Subject: RE: Planning Consultation on: A/255/21/DOC

Thanks for these details. Please see below further comments from our drainage engineer:

<p>cgs civils Consulting Civil Engineers</p>					
CLIENT		GD GROUP			
ARCHITECT		CITYZEN			
JOB TITLE		MERRY ENGLAND ANGMERING			
DRAWING TITLE		DRAINAGE LAYOUT			
DRAWN	LH	ENGINEER	CS	CHECKED	CS
DATE	SEPT 2019		1:200		
DRAWING No.	C1249	STATUS	C	DRAWING No.	100
REV	A

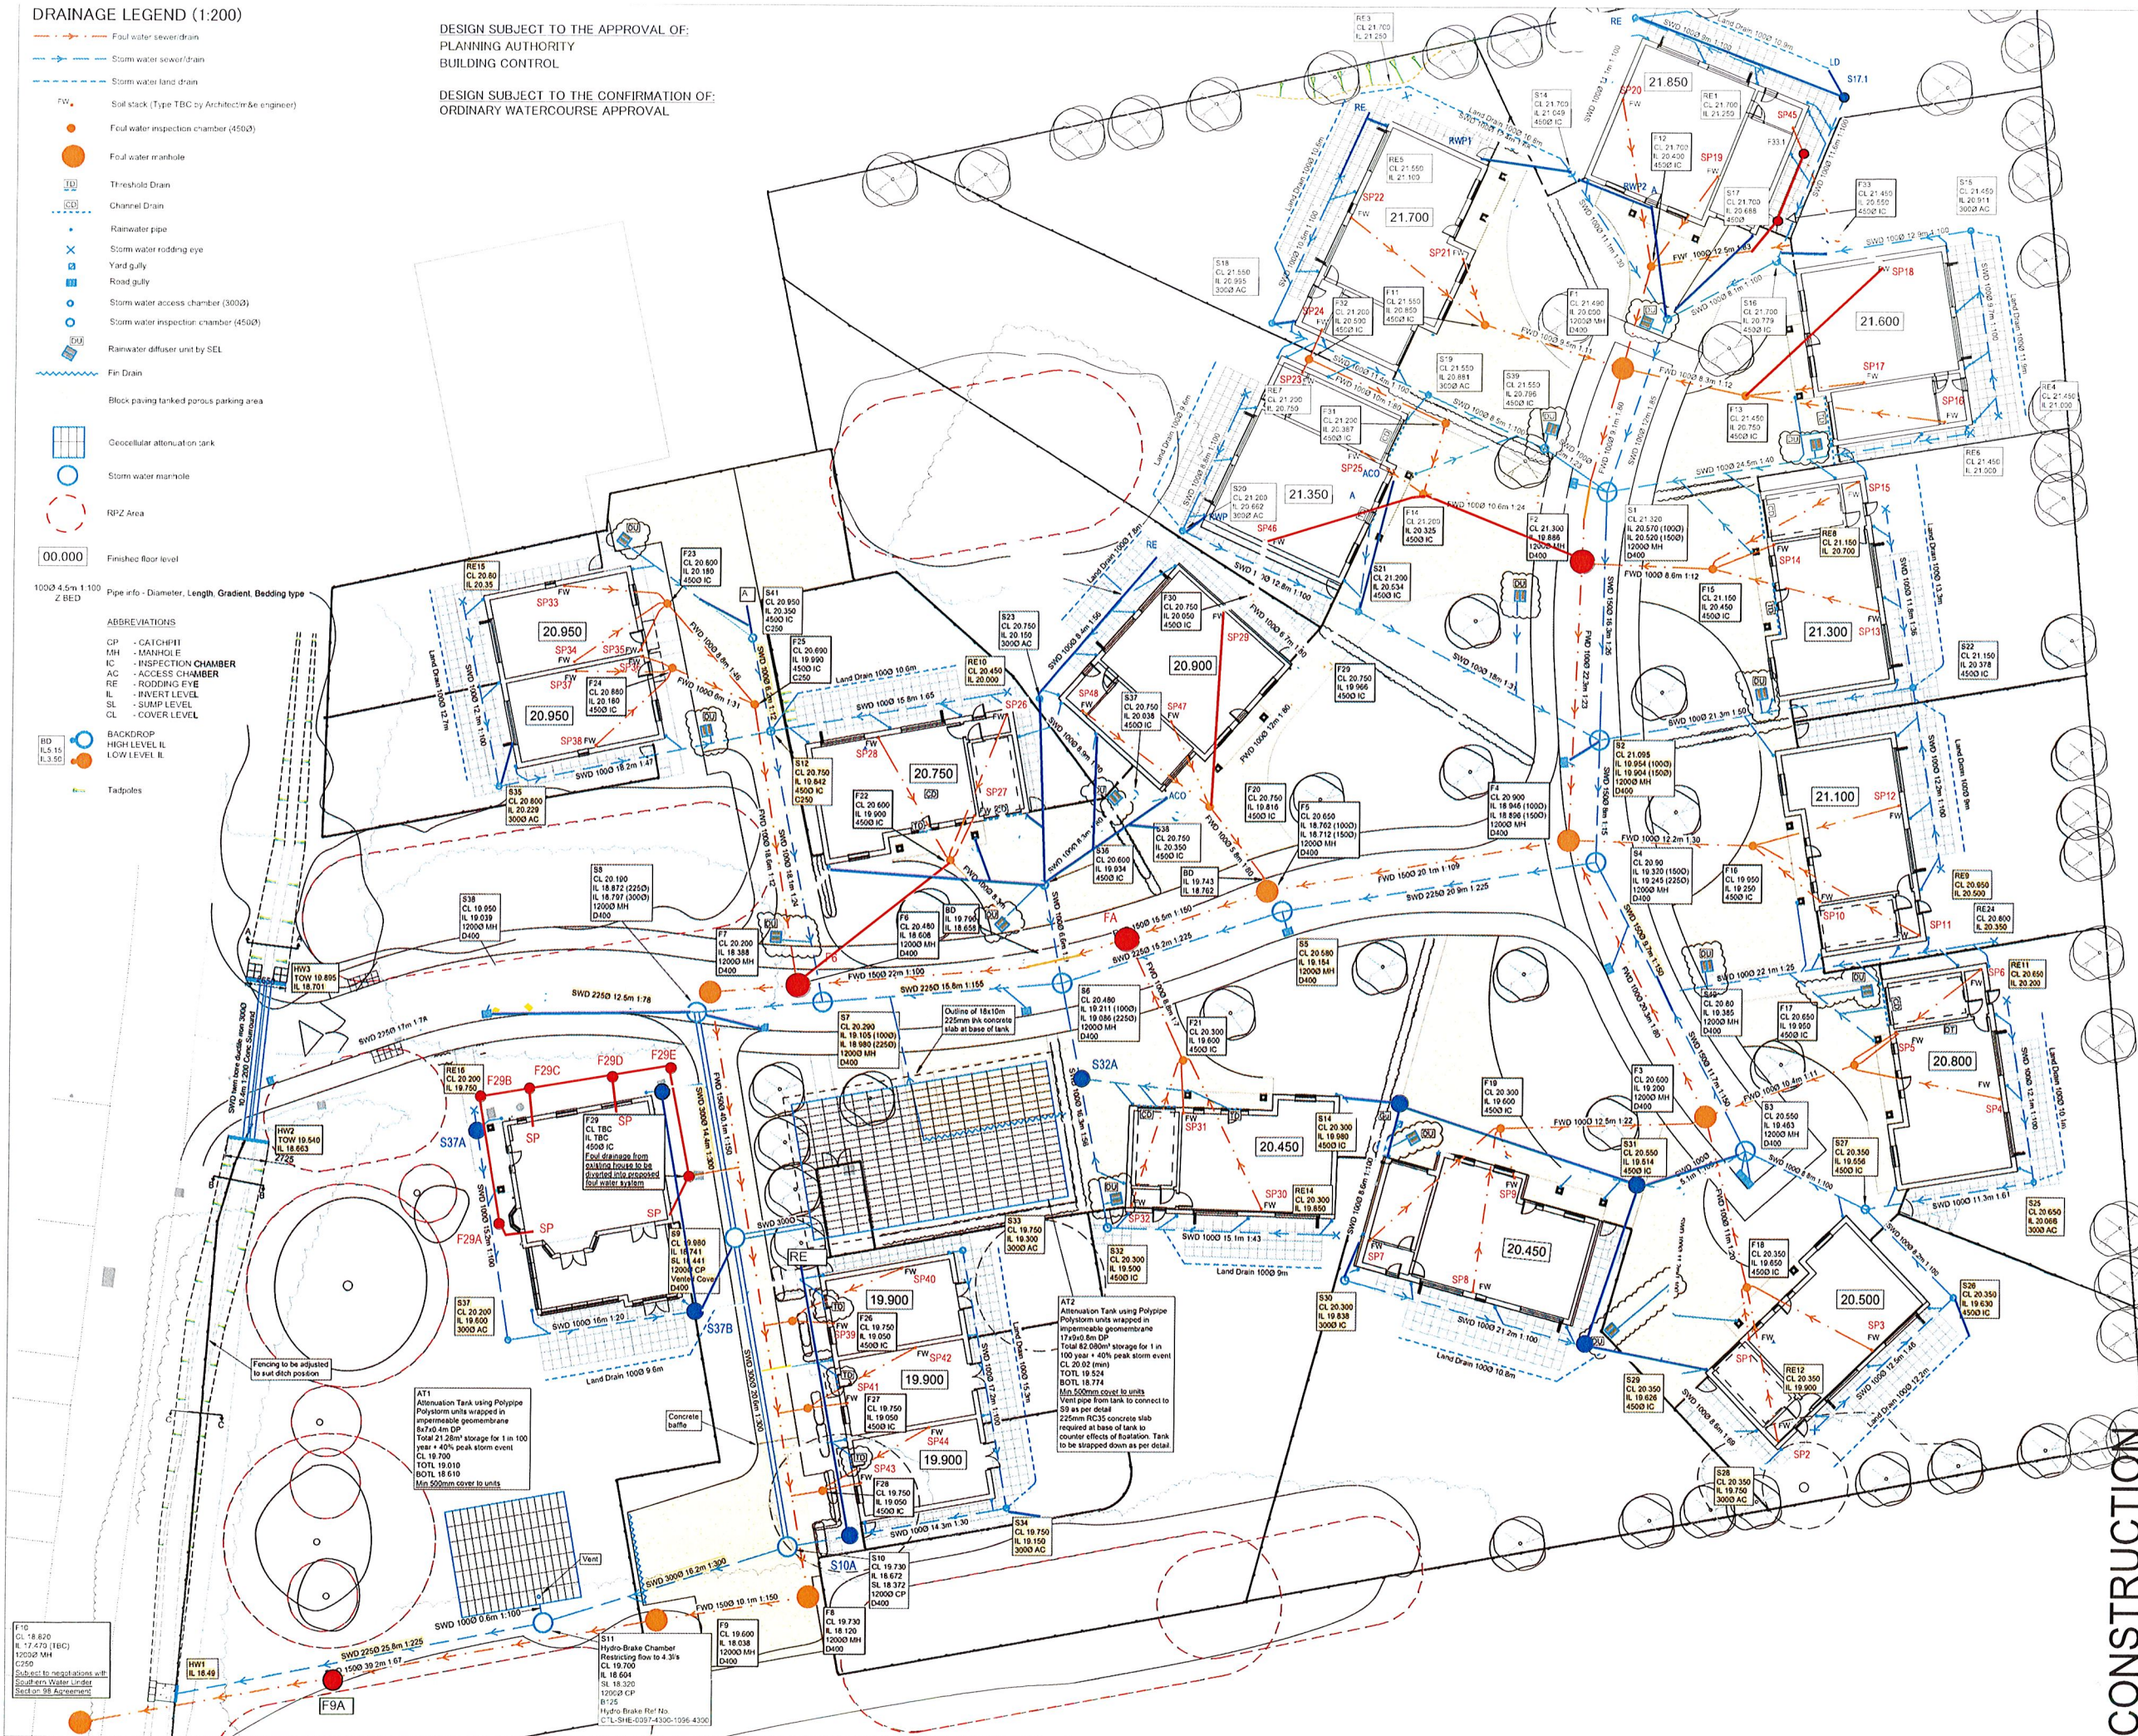
The invoice for the attenuation tanks states that 196 Polystorm PSM1 crates were ordered. We believe that the design requires over 700 crates.

The photos supplied to evidence the construction of AT2 clearly show that this attenuation tank has been constructed to only one crate depth, despite the design specifying two crates depth. The photo also appears to show Terram surround the crates, but no impermeable tanking membrane.

Please also clearly detail if each of the defects picked up by the independent engineer have been rectified. Five photos have been supplied, but more than 5 defects were identified.

We do not recommend discharge of condition 5 at this time as the evidence supplied raises significant questions about the construction. Please supply evidence that construction has occurred in accordance with the design. It may be that some areas need to be reconstructed.
